Appeal Decision

Appeal Ref: APP/R5510/D/23/3325944

14 Warren Road, Ickenham, Hillingdon, UB10 8AA

- The appeal is made under section 78 of the Town and Country Planning Act 1990 against a refusal to grant planning permission.
 - The appeal is made by Mr Gill against the decision of the Council of the London Borough of Hillingdon.
 - The application Ref 35699/APP/2023/1115, dated 16 April 2023, was refused by notice dated 12 June 2023.
 - The development proposed is part single storey, part two storey side/rear and front extension incorporating roof alterations.
-

Roof - Proposed

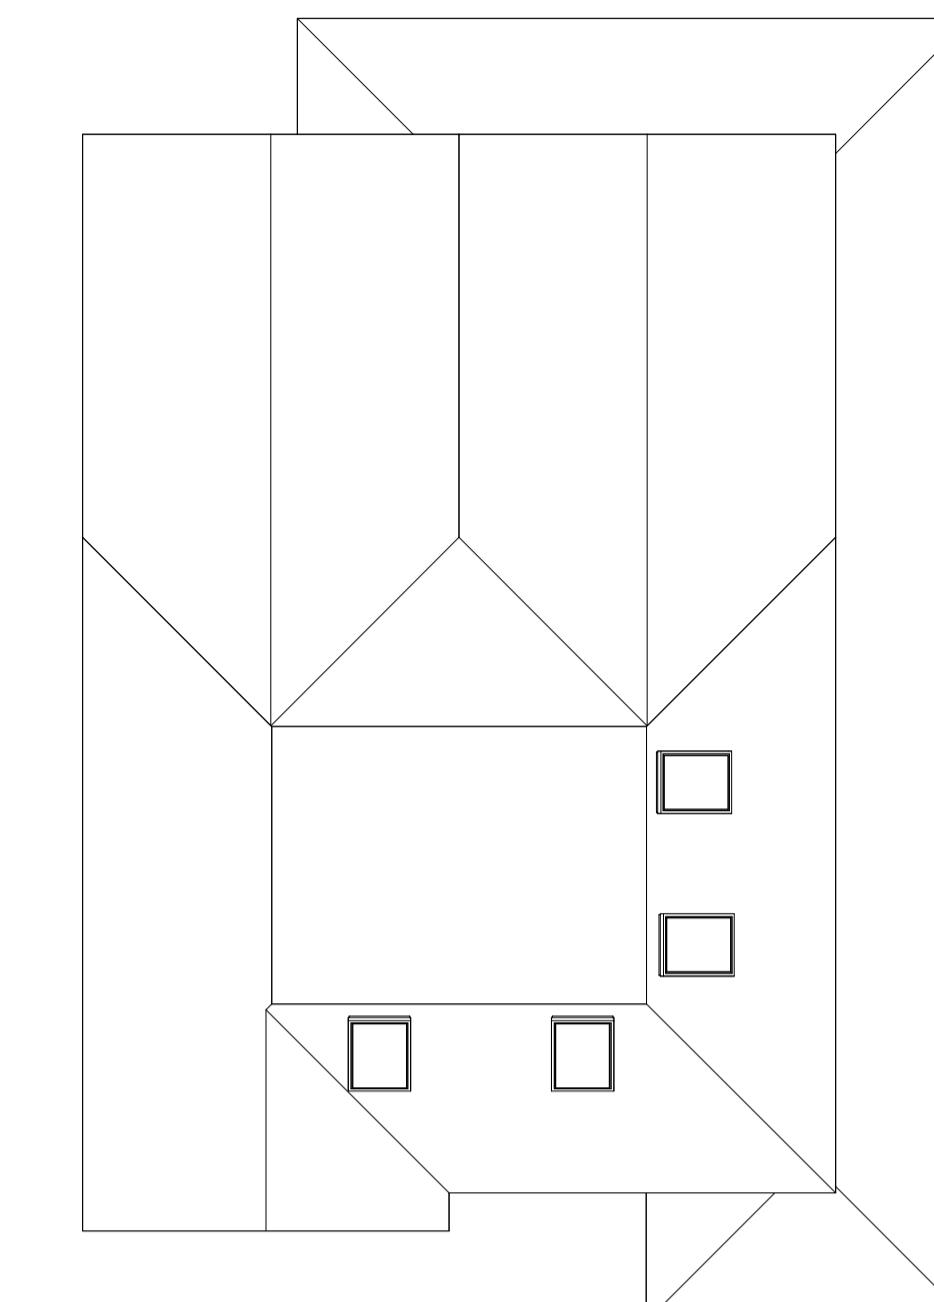
6. The proposed two storey rear extension, together with the loft conversion and alterations to the roof of the dwelling would however add considerably to the bulk and mass of the dwelling compared to the earlier appeal proposal.

8. The proposed would also result in two long unrelieved flank walls. Whilst the roof would be hipped, the depth of the proposed extension together with its roof form, accentuated by its flat crown roof section, would represent a bulky and incongruous addition to the dwelling which would be harmful to its original character and appearance.

East elevation - Proposed

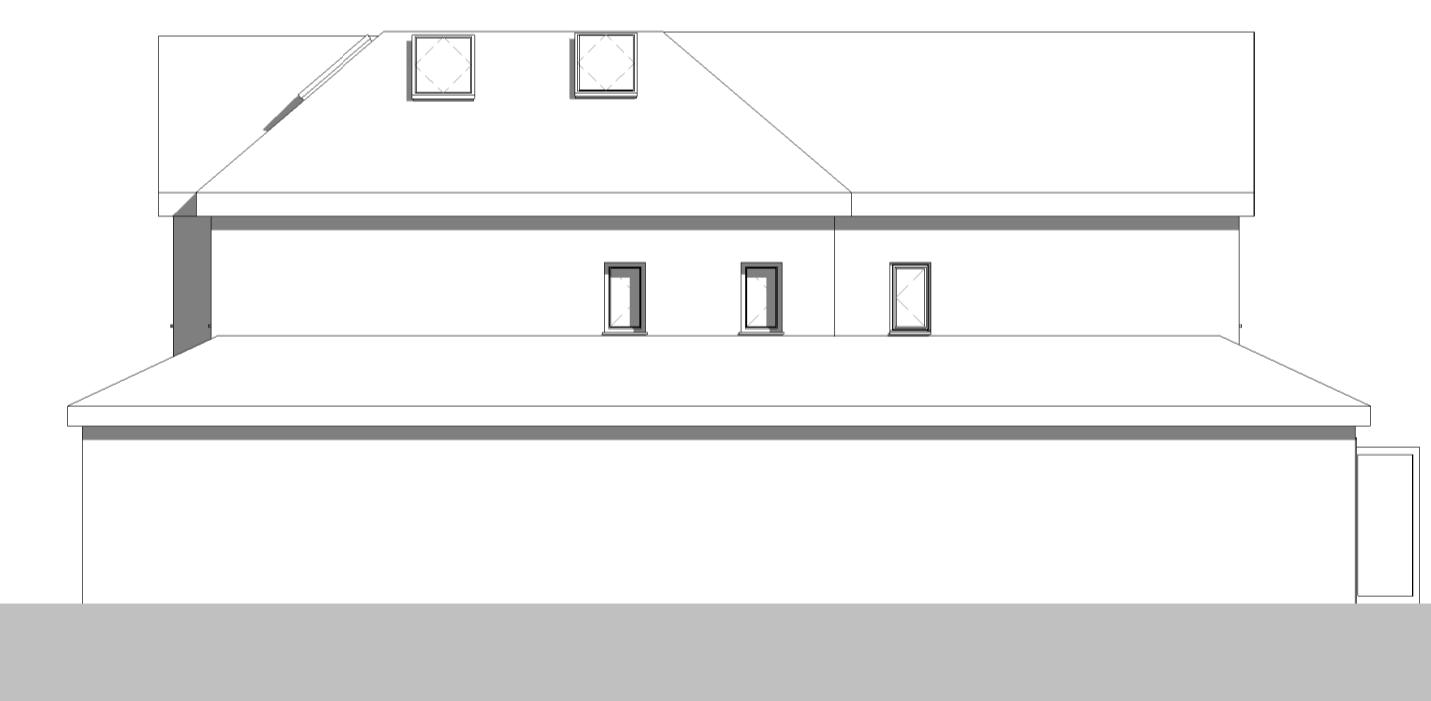
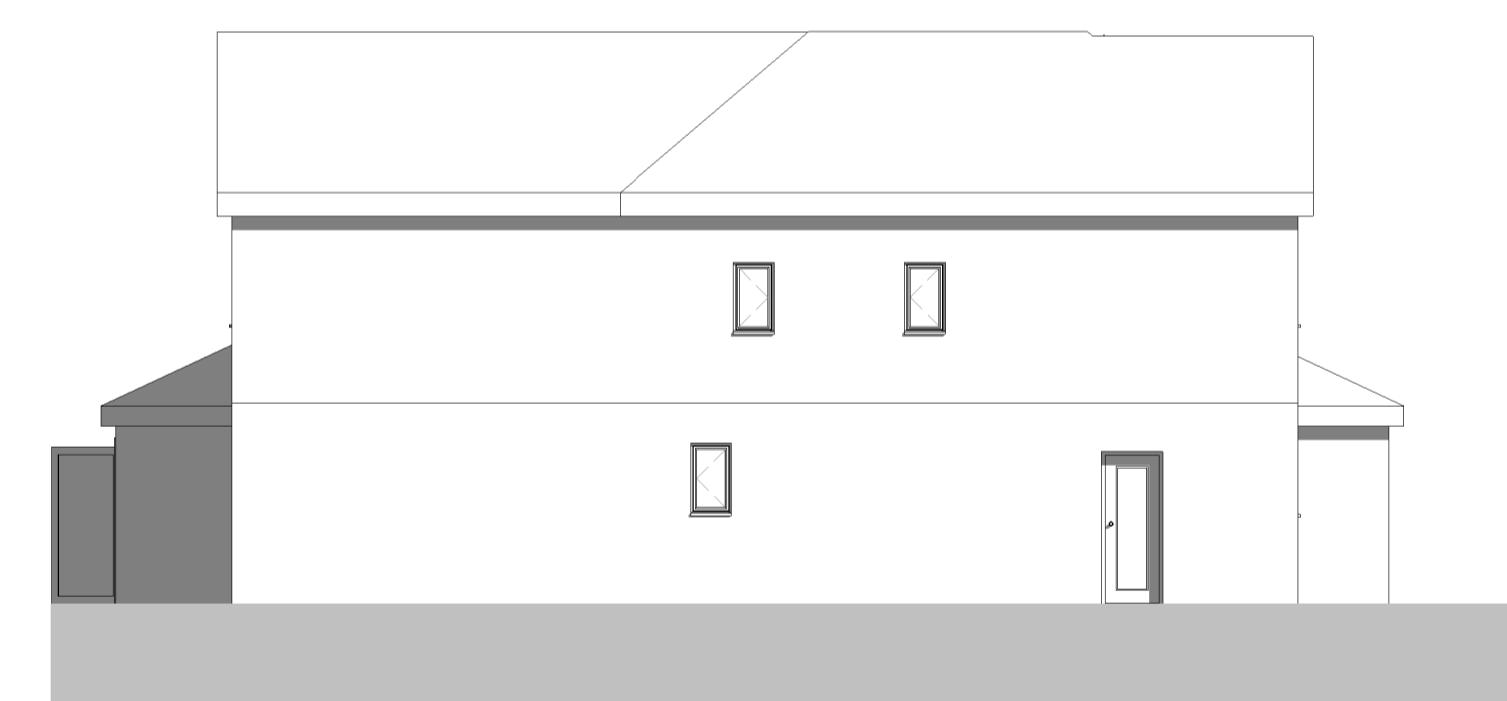
9. I appreciate that the rear elevation would only be visible from adjoining rear gardens and would not be visible in the public realm. However, views of the long flank elevations and the bulky crown roof structure would be obtainable from Warren Road, particularly through the gap between the appeal property and the steep side catslide roof of No 16. Whilst there are properties in Warren Road with crown roof sections including the highlighted examples at Nos 25 and 48 Warren Road, in my view, the appeal proposal would combine deep flank elevations with a relatively large flat roof crown section, which would be at odds with the steeply hipped roof form of No 16 and the modest pitched roof of No 12 and in this regard would be harmful to the character and appearance of the surrounding area.

Rear elevation - Proposed

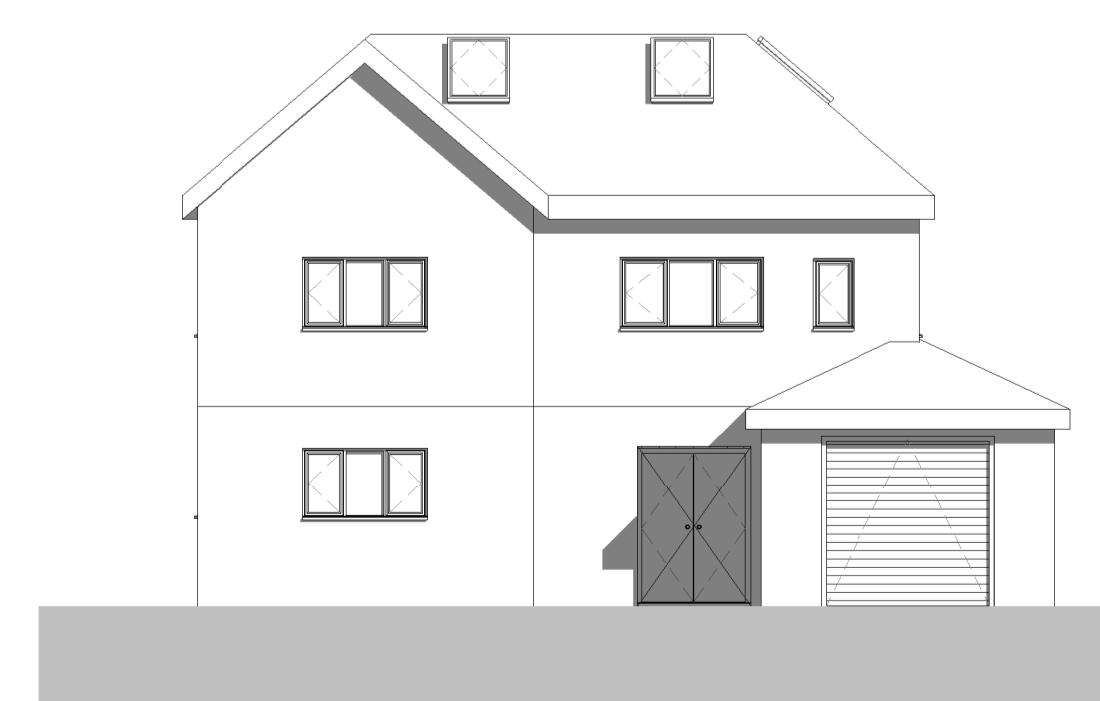
7. The proposed rear elevation would extend across the full width of the dwelling and would fully obscure the existing rear elevation. The extension would have the same eaves and height as the host dwelling and accordingly, would not be subservient in appearance. Moreover, the proposal would introduce a double gable feature on the rear elevation of the new roof with glazed gable ends which, in my view, would be highly dominant and would overwhelm the character and appearance of the existing dwelling.
